TOWN AND COUNTRY PLANNING ACT 1990 NON MATERIAL AMENDMENT

Reference: H08-1031-25 **Date of Decision:** 31st October 2025
Applicant: R K Wilson Builders Ltd.
C/O Robert Doughty Consultancy Limited
32 High Street
Helpringham
Sleaford
NG34 0RA
Location: Riseholme Farm Windmill Lane Gosberton Risegate Spalding
Description: Erection of 6 single storey dwellings and garages, formation of parking and bin collection point and reinstatement of existing access - approved under H08-0282-24. Amendments to foundation design to that required under Condition 3 of approval H08-0282-24

South Holland District Council hereby give notice that this application has been REFUSED in respect of the non-material amendments referred to above for the following reason(s):

SECTION THROUGH E-E INTERNAL
215mm THK. SLEEPER WALL
SCALE 1:20

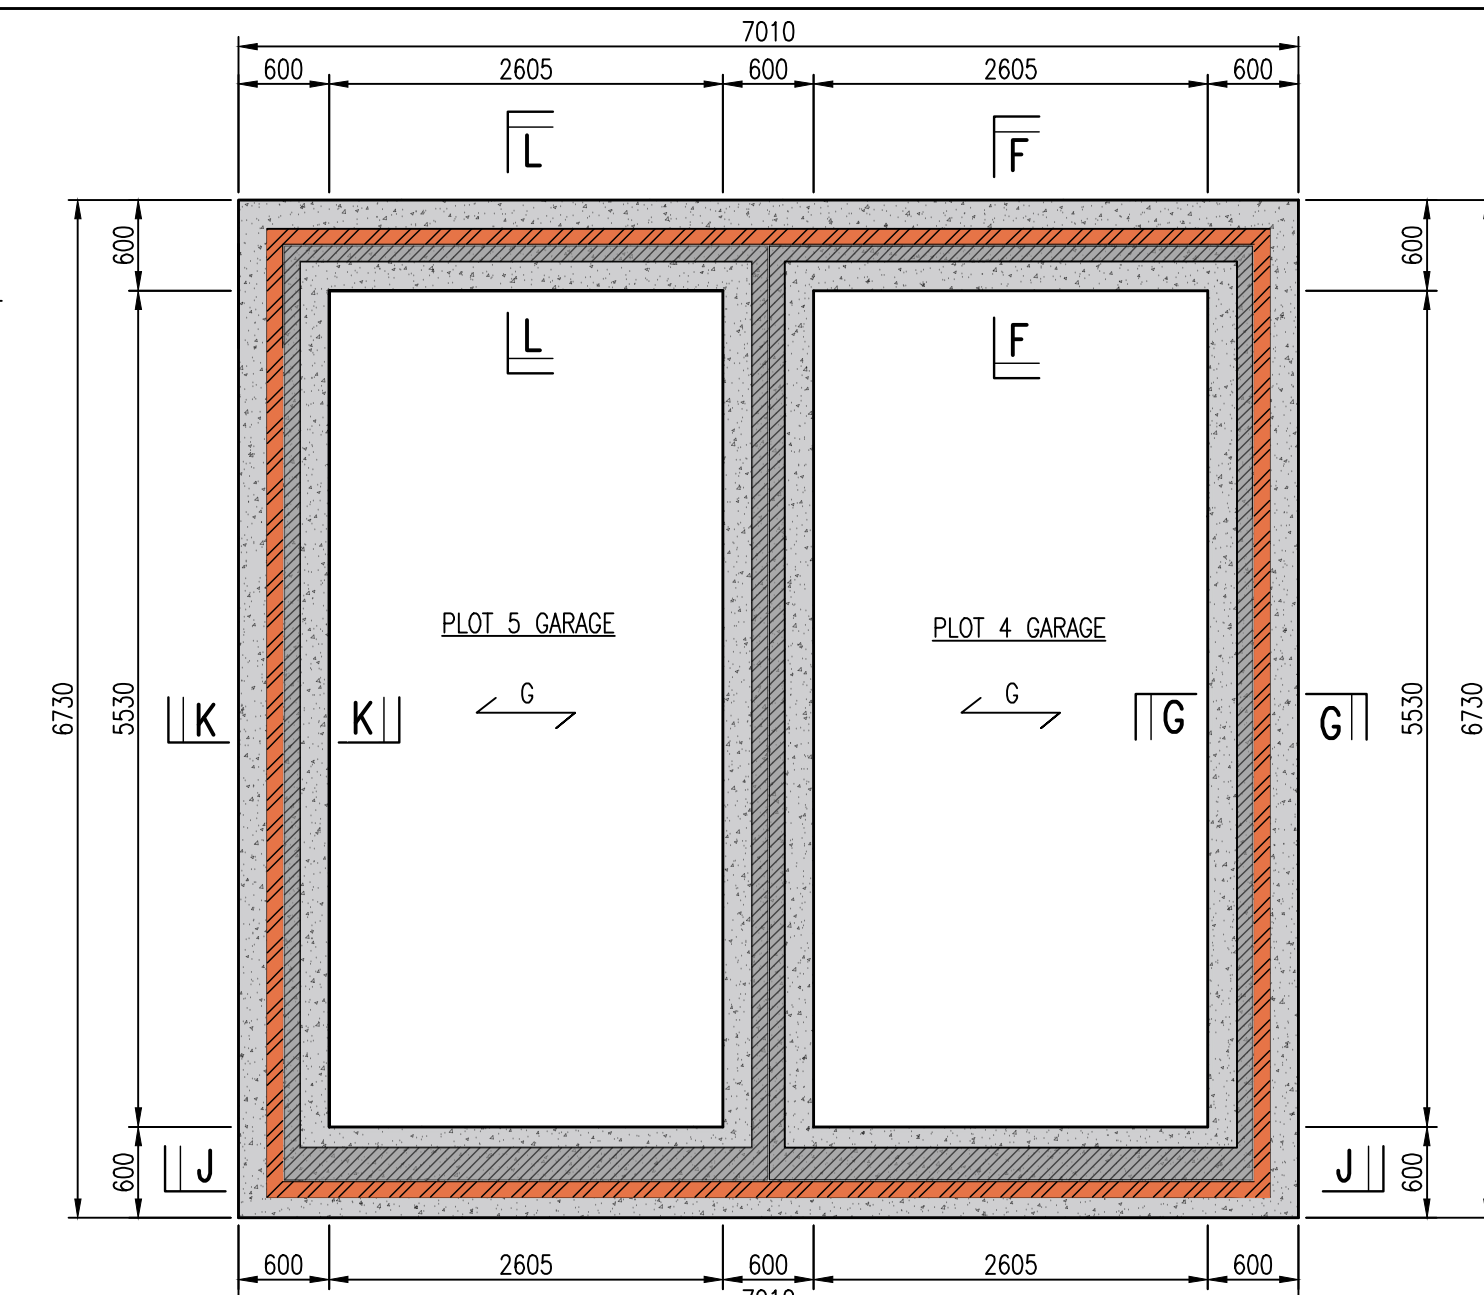
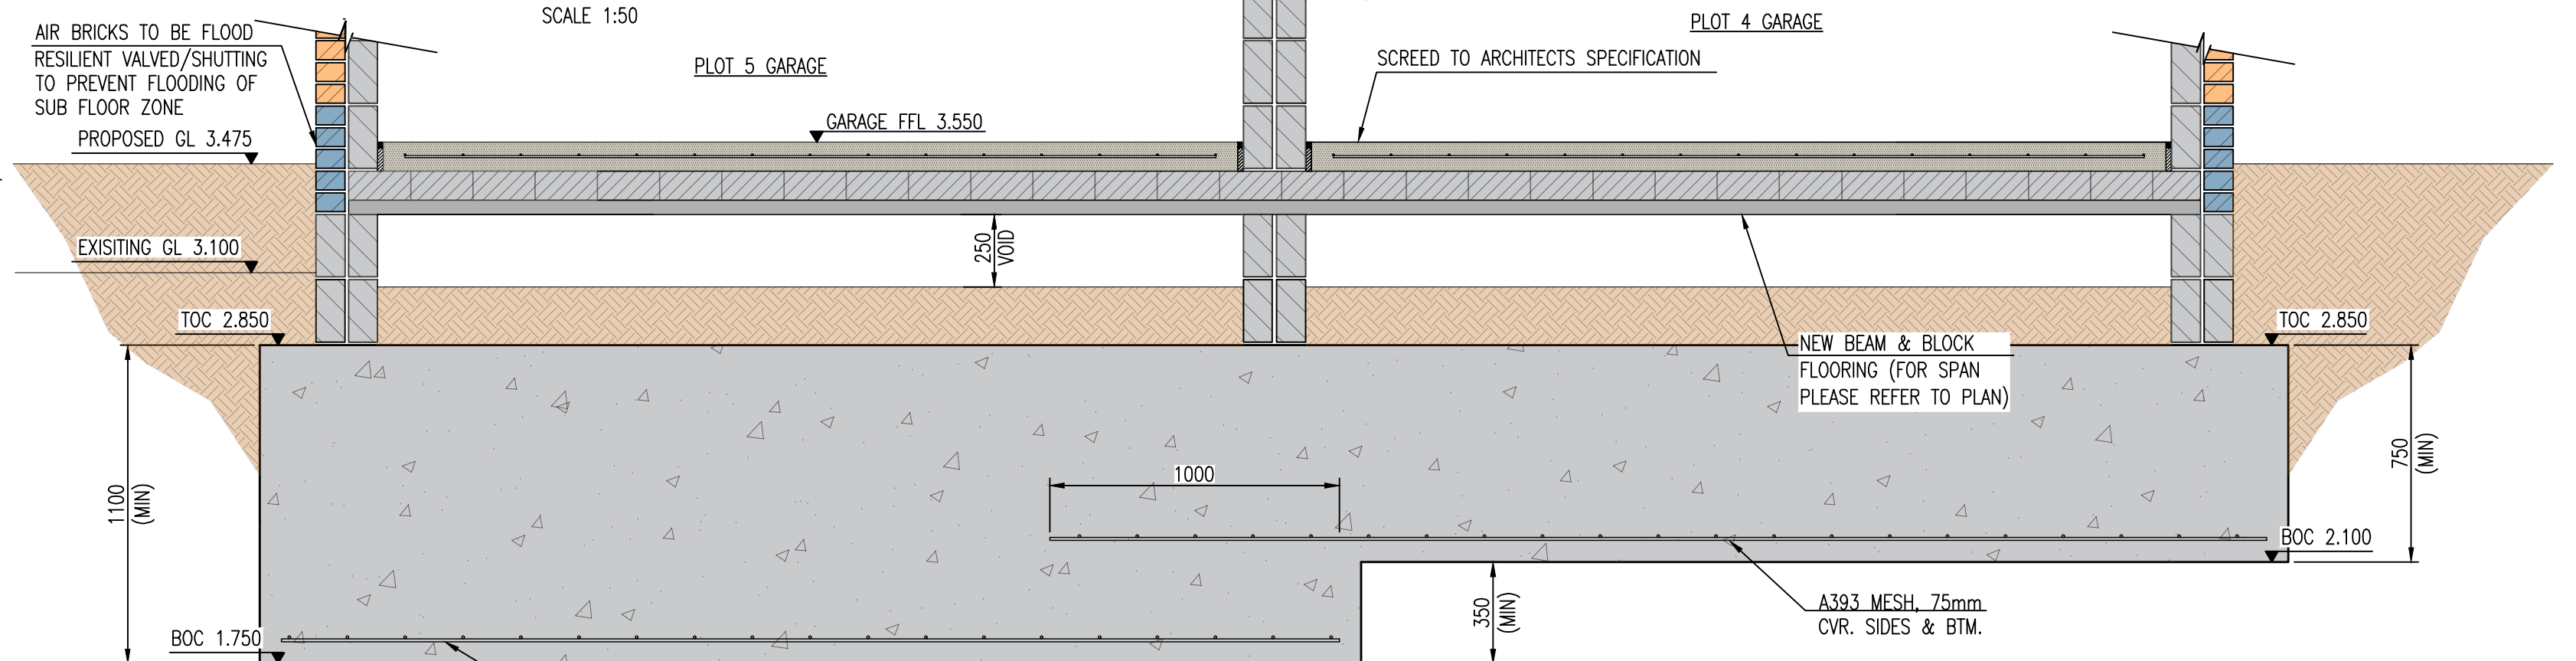
- 1 Point 8 of South Holland District Council's guidance on non-material amendments confirms that such amendments must not result in a fundamental change to the design of the approved building. The approved Flood Risk Assessment (FRA) by RM Associates establishes a critical flood resilience requirement that "the ground floor shall be constructed with a solid concrete floor with no voids beneath and no low-level wall vents." The proposed introduction of a strip foundation incorporating voids beneath the floor would fundamentally alter this key element of the approved design and directly conflict with the flood mitigation measures integral to the scheme's acceptability.

Accordingly, the amendment would constitute a material change to the approved development and cannot be treated as a non-material amendment under Section 96A of the Town and Country Planning Act 1990 (as amended).
